CITY OF ALBUQUERQUE

**RE: Gold Avenue Casitas
Grading and Drainage Plan
Engineer's Stamp Date 10-1-2014 (File: K15D098)**

Based upon the information provided in your submittal received 10-2-014, the above referenced plan is approved for Building Permit with the following condition:

sheet title
GRADING & DRAINAGE PLAN

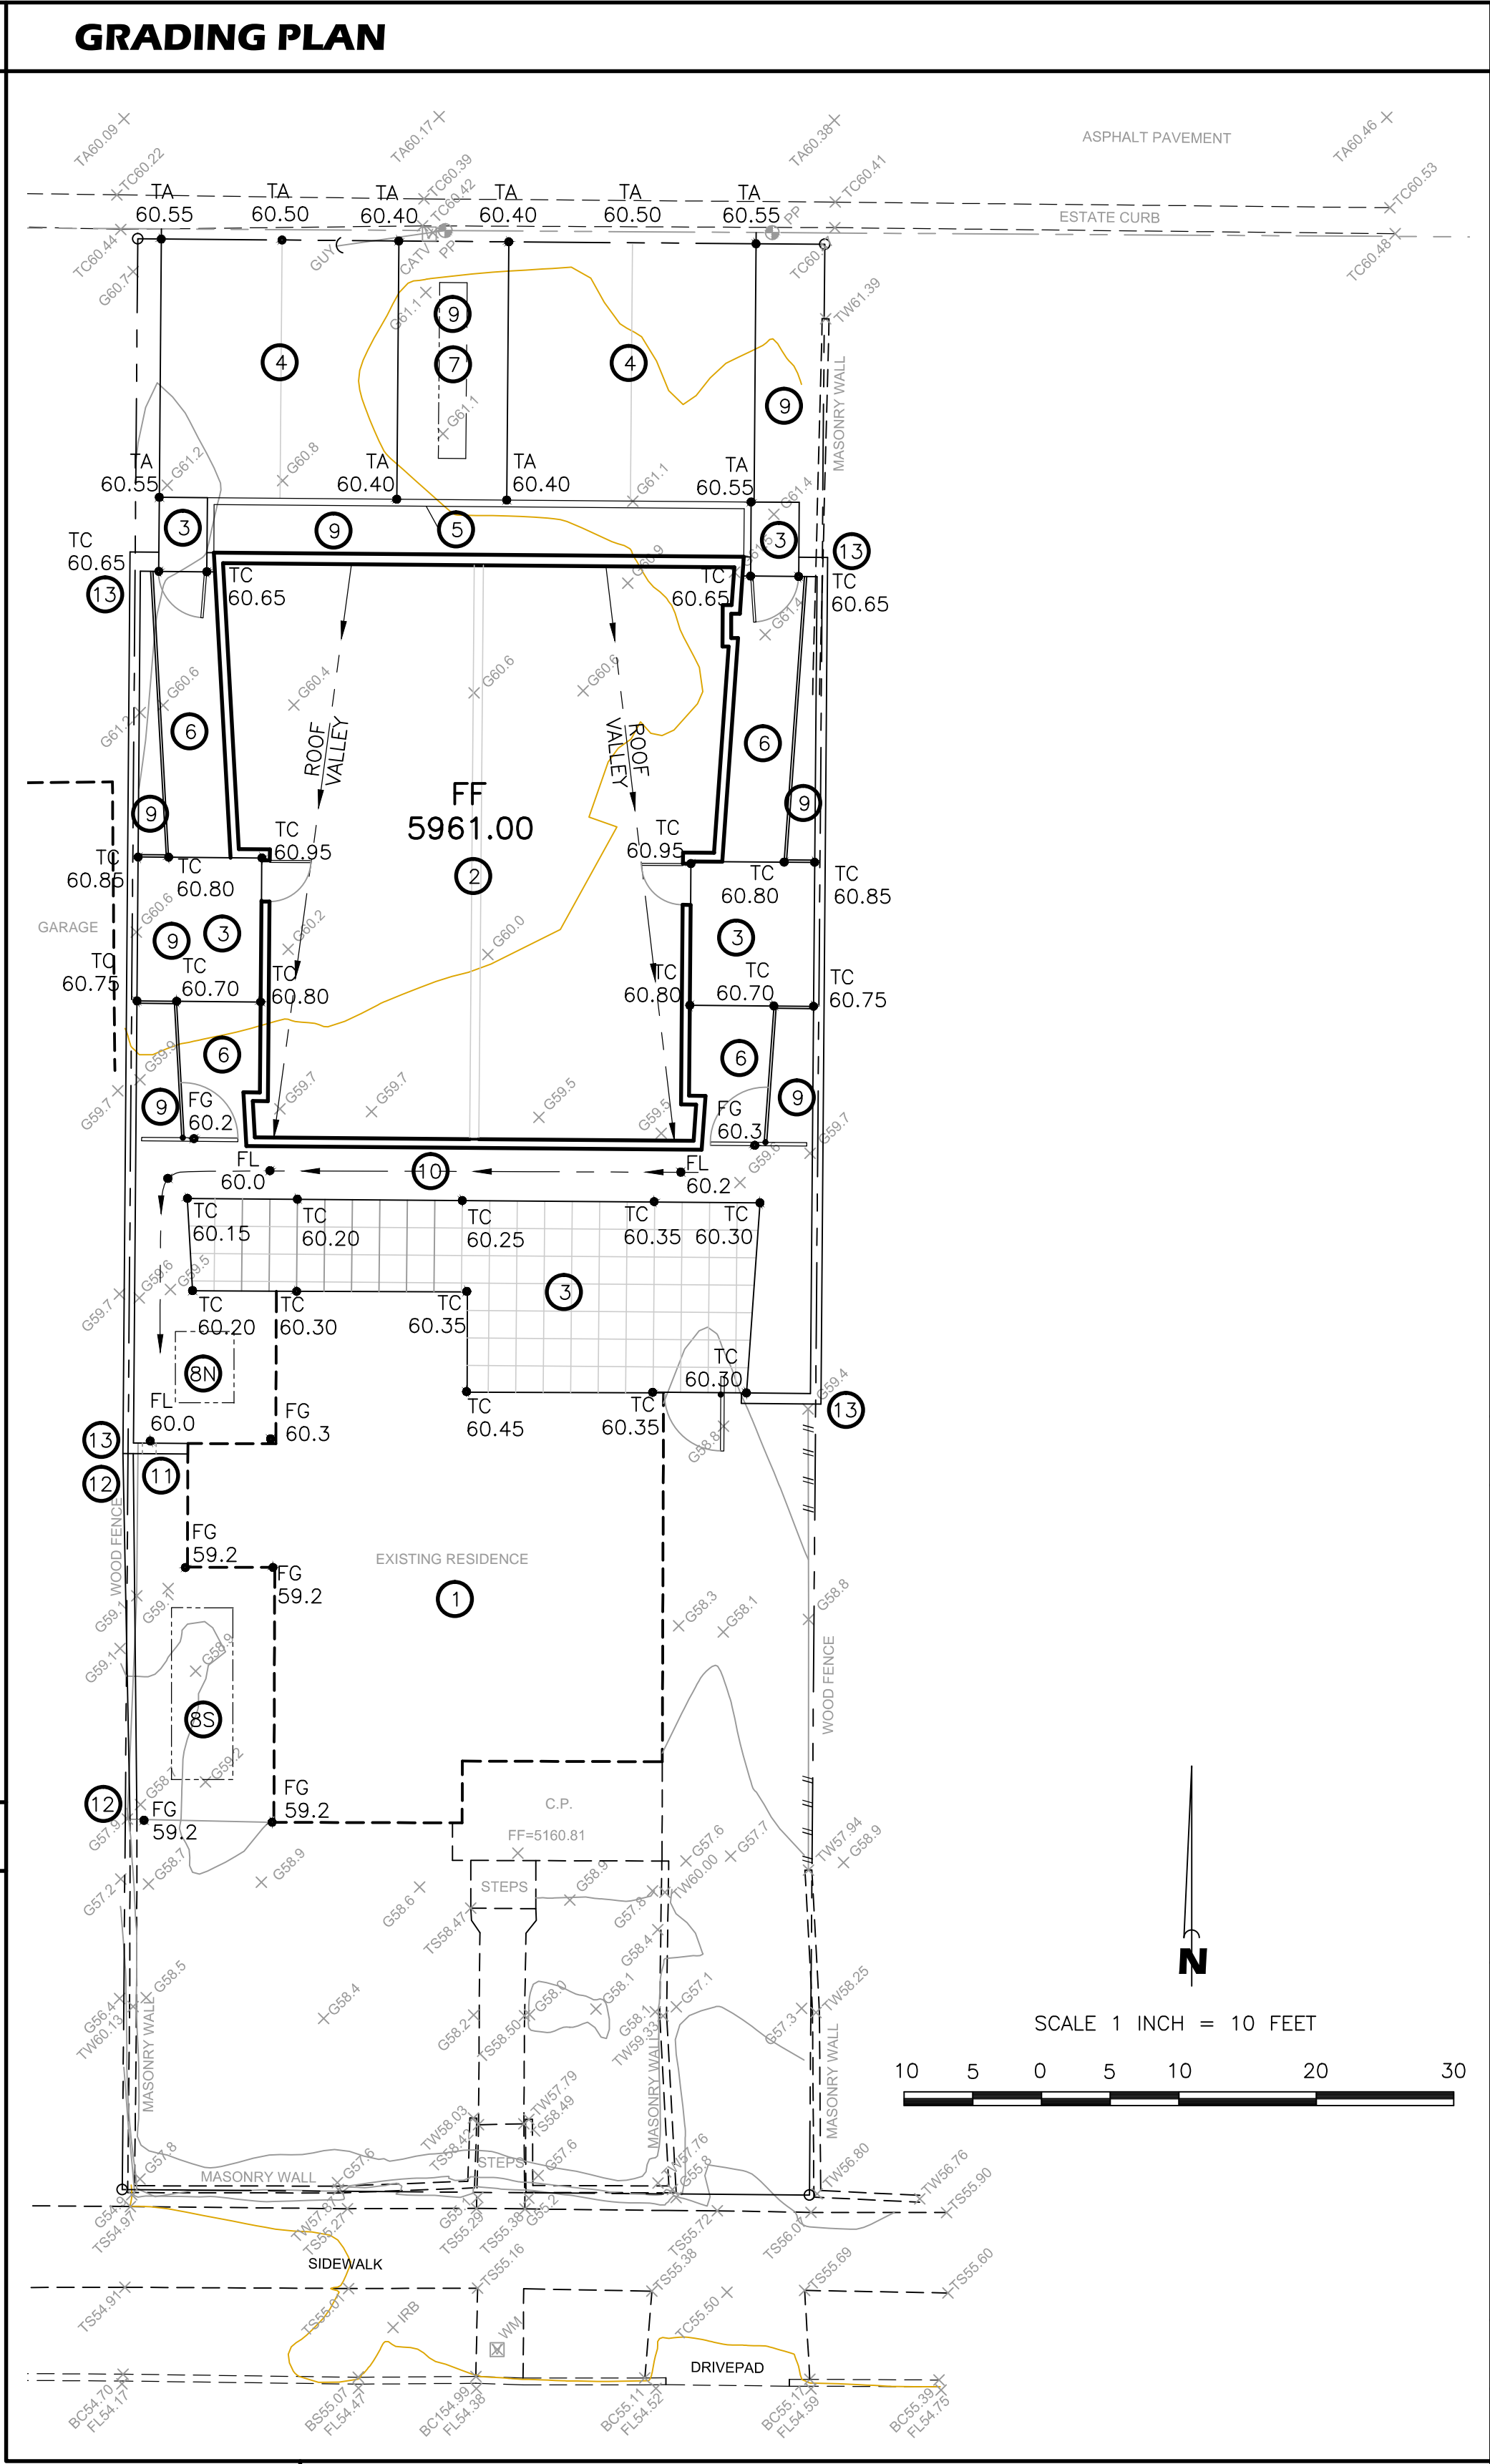
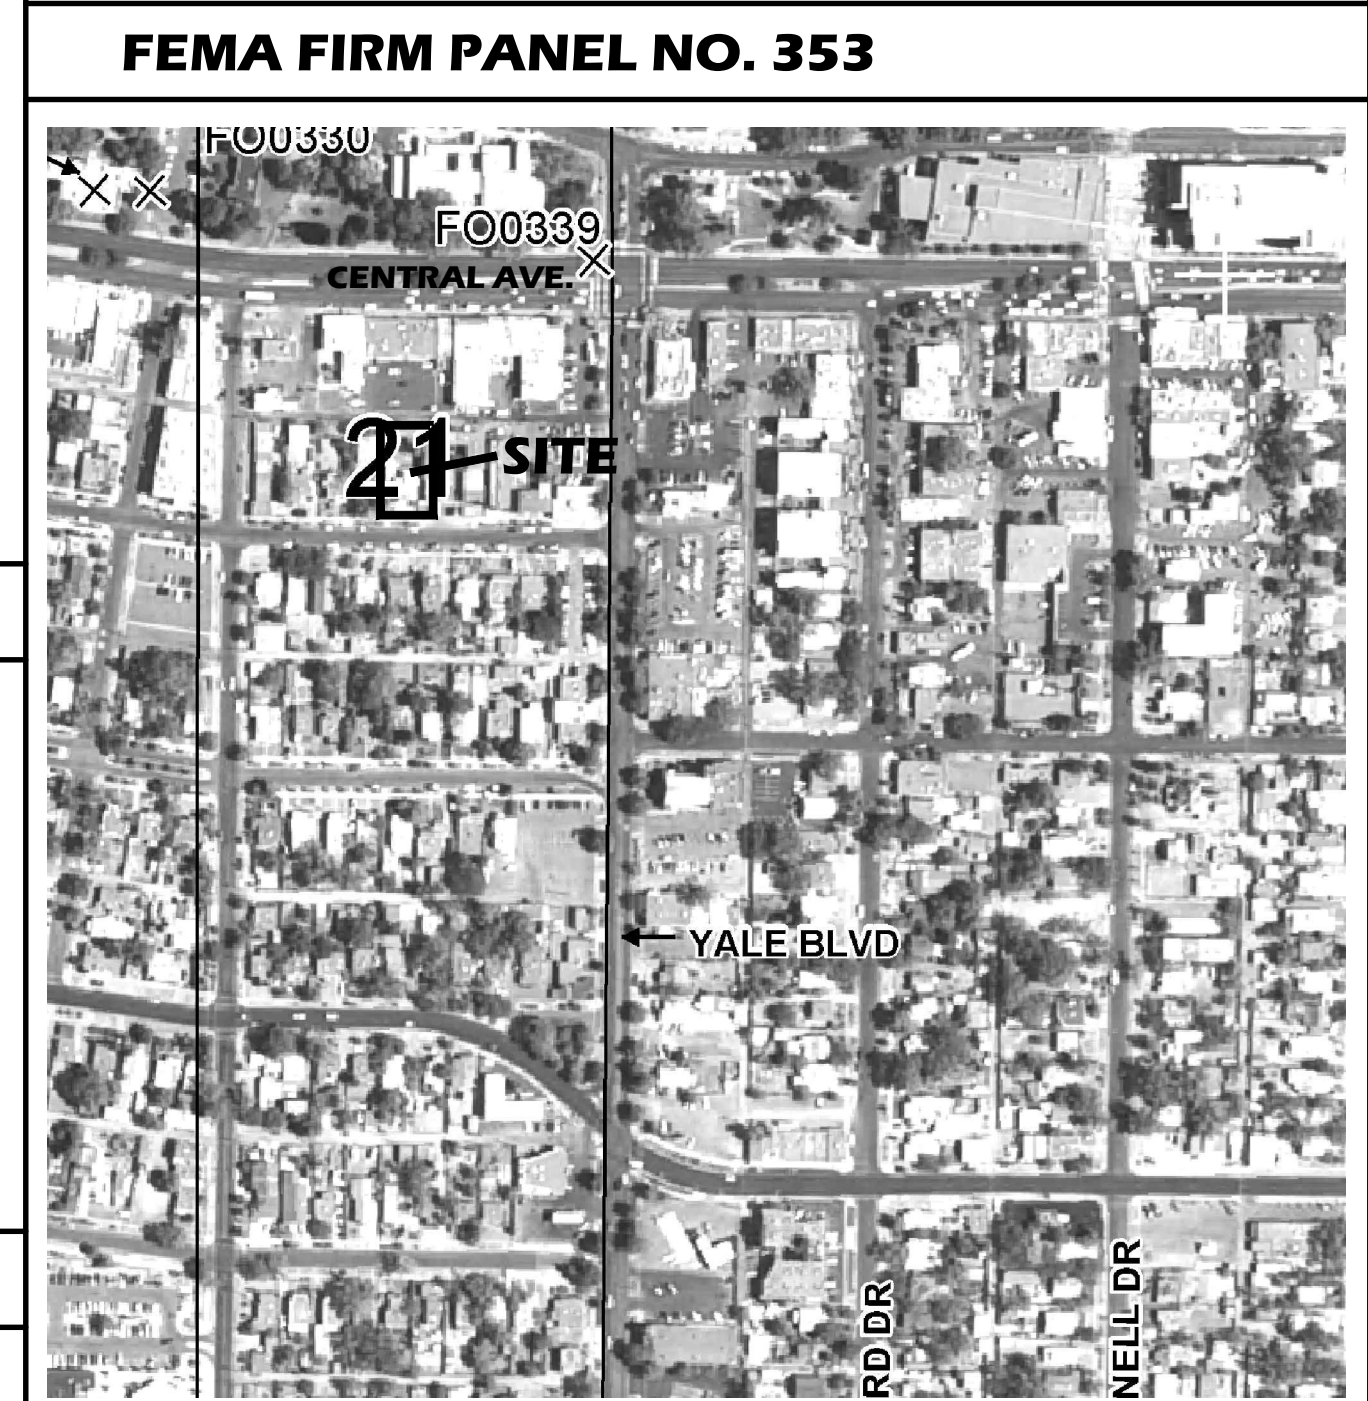
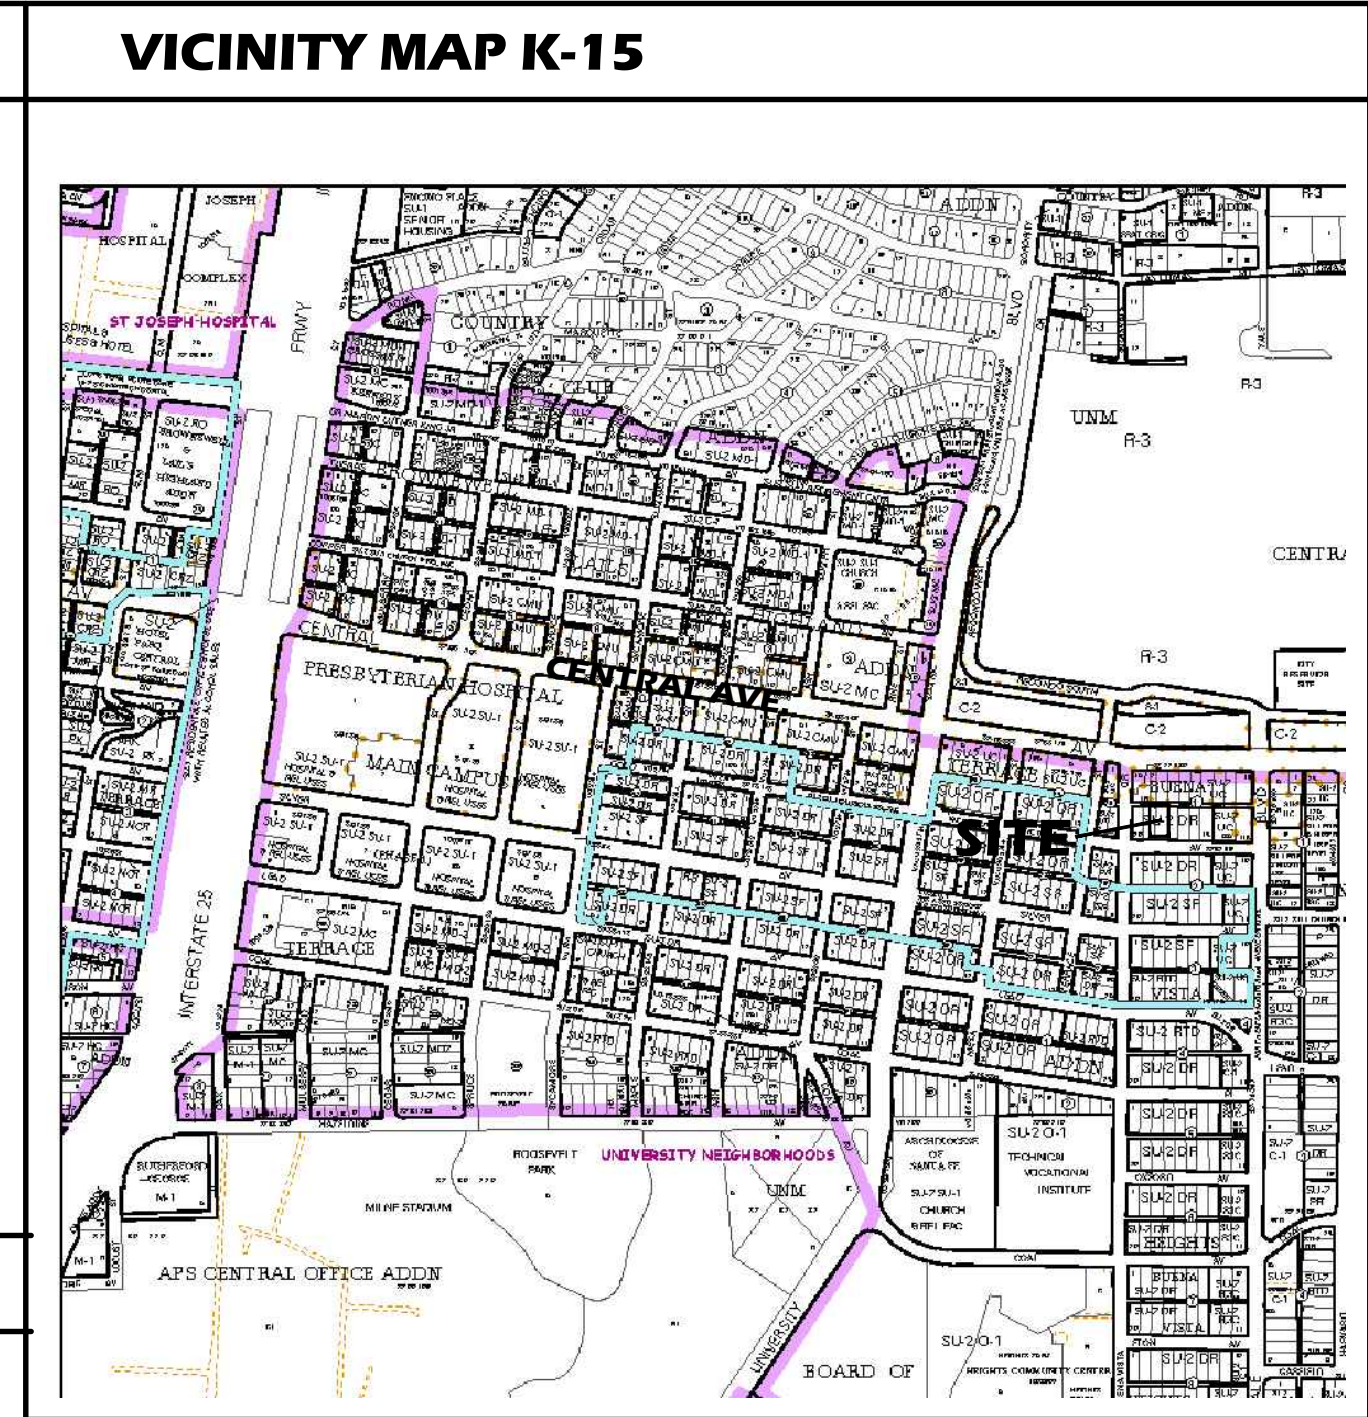
1. A drainage swale needs to extend from the 8-South pond to the drivepad to allow rainfall in excess of the first flush to discharge to the street. The fence would be removed to allow for the flow.
